Project Name:	170 Anderson Street	Project ID:	2014-075
Address:	170 Anderson Street	CBL:	010 E002
Applicant:	Sherwood Hamill		
Planner:	Barbara Barhydt, Development Review Services Manager

On July 18, 2014, the Planning Authority approved with conditions a Level II site plan for the building ramps and site work for at 170 Anderson Street. The decision is based upon the application, documents and plans as submitted for the application and prepared by Ryan Senatore. The proposal was reviewed for conformance with the standards of Portland's site plan ordinance.

SHEET TITLE:
SITE PLAN
LAYOUT

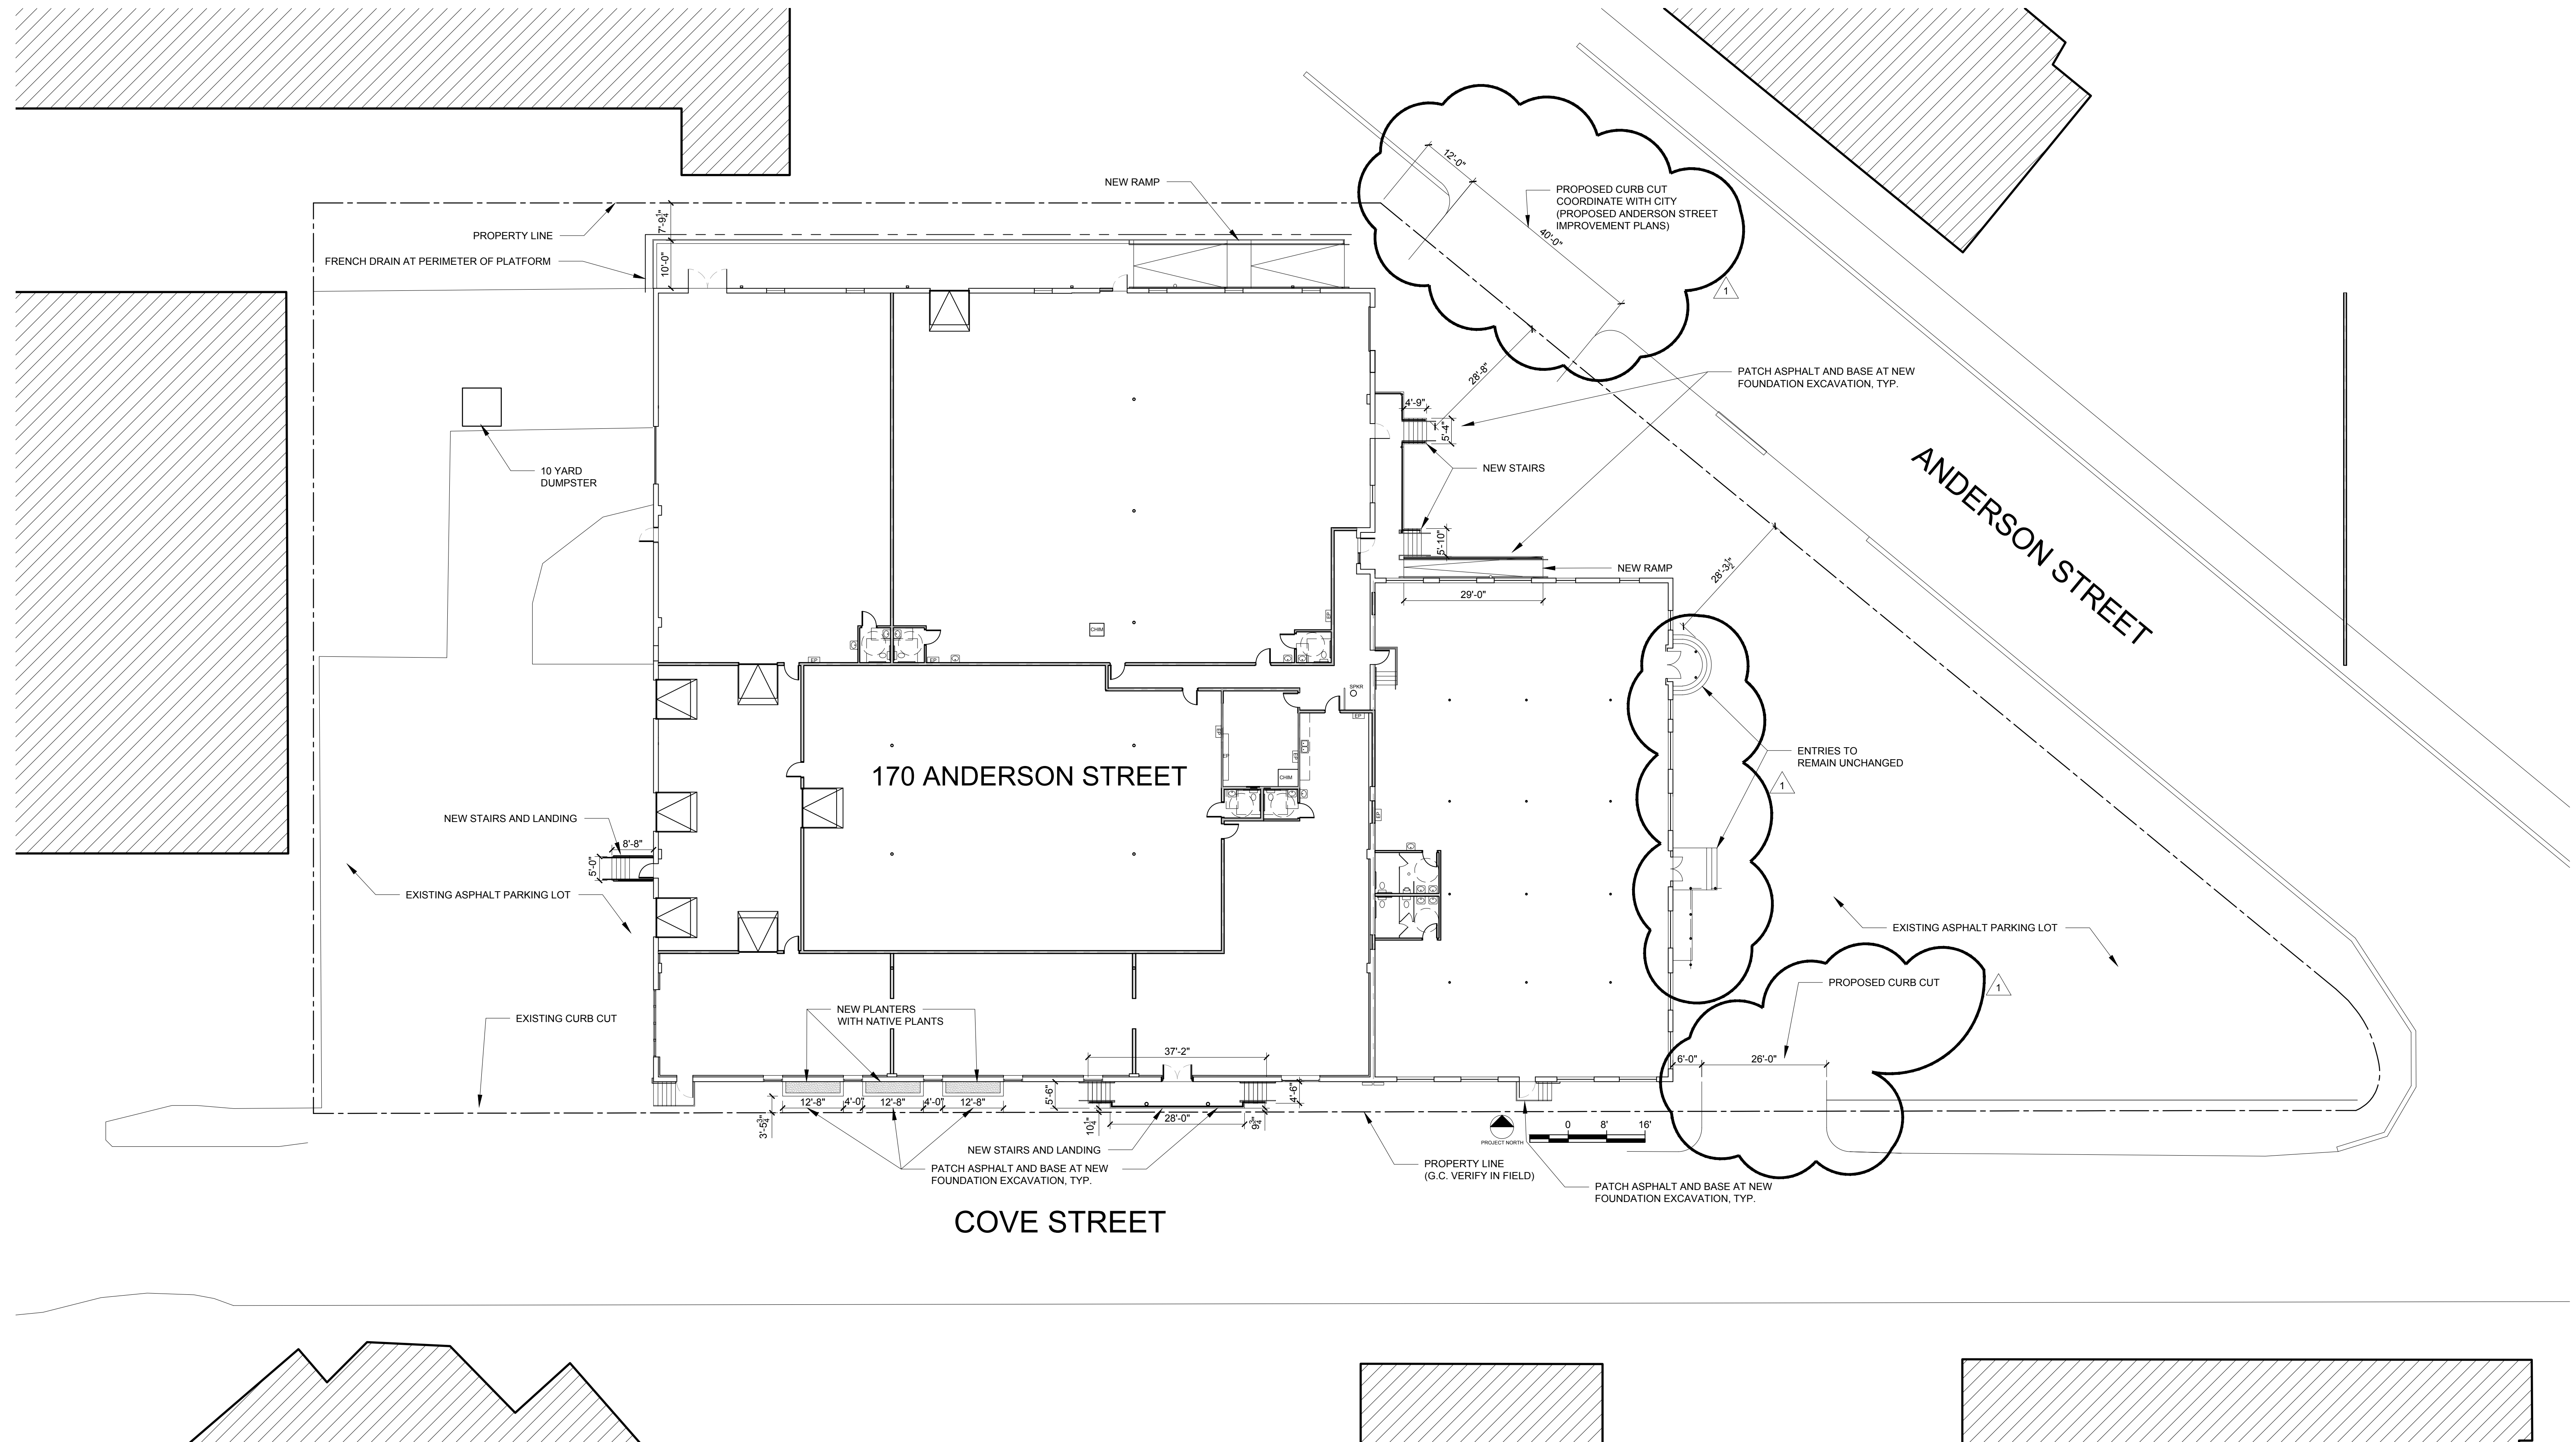
1. The Planning Authority with the support of the Department of Public Services waives the Technical Standard, Section 1.8 Sidewalks and Driveway Aprons for the frontage along Cove Street due to the narrow width of the right-of-way and the applicant's agreement to provide an alternative walking route with an easement for a trail connection to the Bayside Trail, subject to the following condition:
 - a. That the applicant shall submit an agreement or easement for the trail connection over the subject property be submitted for review, approval, and signing by the City prior to the issuance of a certificate of occupancy.

1. Prior to the curb cut modification proposed on Cove Street, a Street Opening Permit shall be required and a pre-construction meeting held to define the scope of work.
2. The applicant is allowed two drive cuts for this property. The maximum width allow for an industrial drive is 30'. When Anderson Street is reconstructed in the summer 2015, the City will work with the applicant to locate one 30' wide cut on Fox St. Until then no modifications to curb cuts on Fox St are required.
3. Applicant is requested to bicycle parking to accommodate two bikes.
4. The applicant shall submit an agreement or easement for the trail connection over the subject property be submitted for review, approval, and signing by the City prior to the issuance of a certificate of occupancy.
